RE: **Lot 16 Block 6 SAD 228**  
**6220 Camino Alto NW**  
**Volcano Cliffs Subdivision**  
**Grading and Drainage Plan**  
**Engineers Stamp Date 7/6/18 (D10D003B16)**

Based upon the information provided in your submittal received 7/6/18, this plan cannot be approved for Grading Permit until the following comments are addressed.

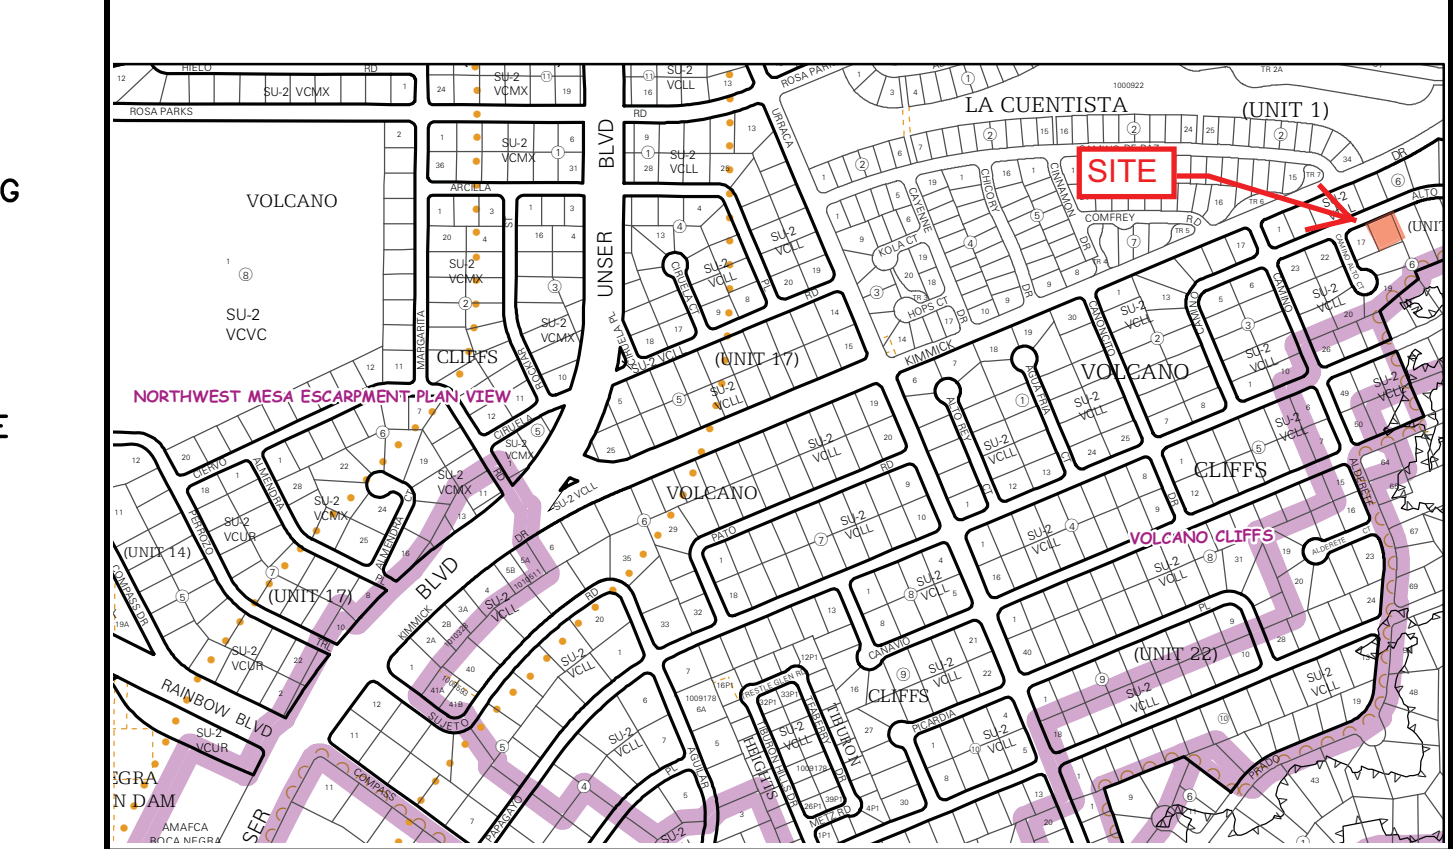
- Show the 10' PUE in the rear yard and side yard.
- Provide one FF elevation.
